March 25, 2024

**Subject: Memorandum for Pavement Thickness Design
Fox Creek Lane Extension at Terra Ridge North
Black Forest, El Paso County, Colorado**

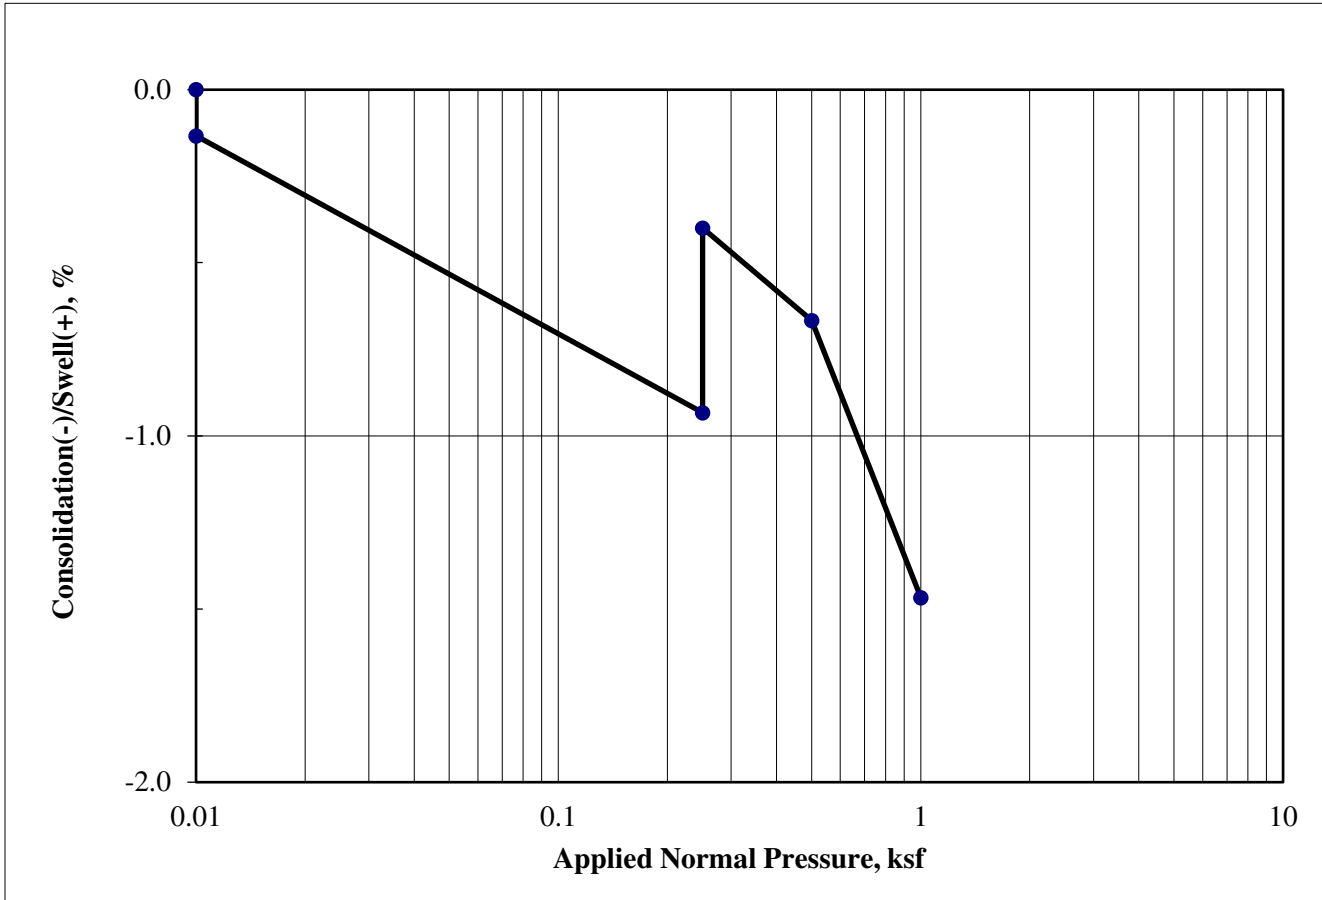
Please darken the text for better clarity

D-2 missing?
Please include the following in the table:

- AASHTO Soil Classification
- % Passing No. 200 sieve
- Soil description
